Rezoning Transportation Analysis

Petition Number: 2022-119

Date	Description
12-29-22	First Review (TM)
02-23-22	Second Review (TM)
05-24-23	Third Review (TM)

REZONING PETITION
FOR PUBLIC HEARING

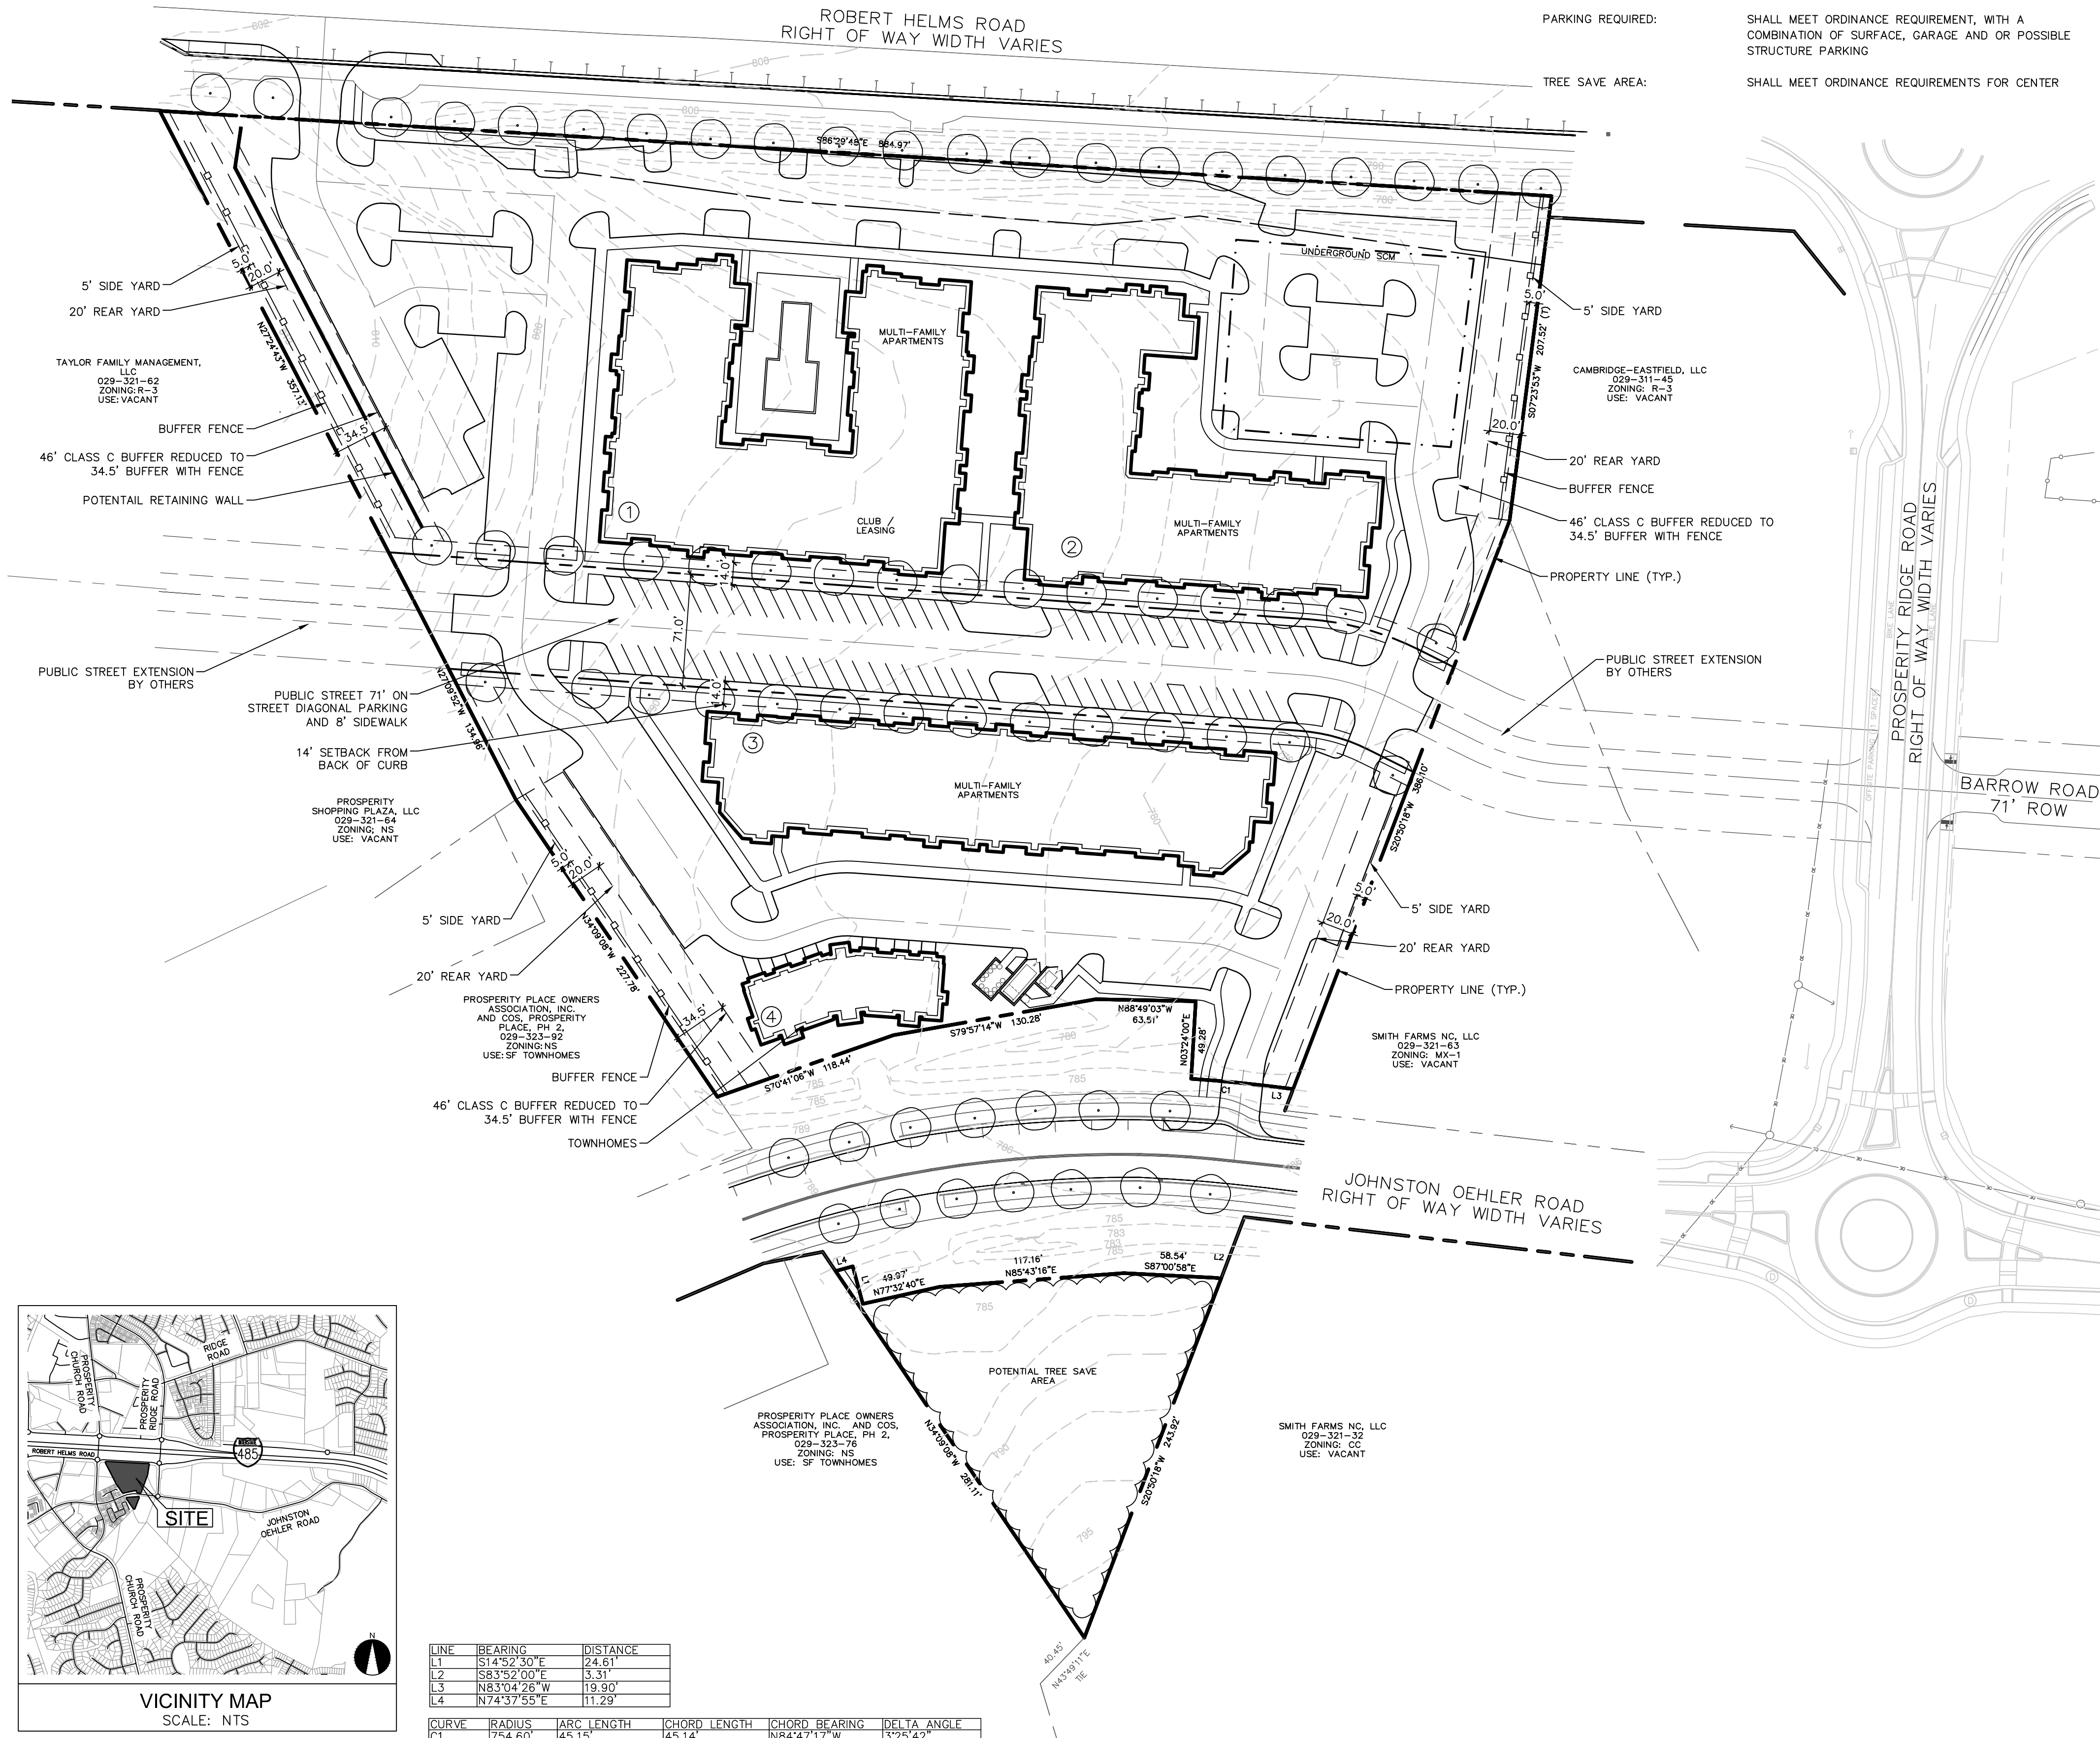
8. **Outstanding Comment form 12-29-22:** Revise site plan and conditional note(s) to commit to existing on-street parking by adding an ADA stall to Johnston Oehler Road and Robert Helms Road.

9. **Outstanding Comment form 12-29-22:** Revise site plan and conditional note(s) to remove the site entrance on Robert Helms Road per NCDOT comments.

Clarifying Comment 02-22-23: Remove all references to a site entrance on Robert Helms Road.

10. **Outstanding Comment form 12-29-22:** Revise site plan and conditional note(s) to extend all public infrastructure along the public roadway extension to the property line.
11. **Outstanding Comment form 12-29-22:** Revise site plan and conditional note(s) to callout the roadway extension roadway cross section per CLDSM.
12. **Outstanding Comment form 12-29-22:** Revise site plan and conditional note(s) by revising on-street parking space along the proposed public roadway extension to be installed as parallel parking stalls. One stall shall be an ADA-compliant stall. **Note:** the proposed internal public road extension cannot be accepted for City maintenance until it is connected to the public roadway system by another public street connection.

Clarifying Comment 02-22-23: Remove all mention of diagonal parking spaces
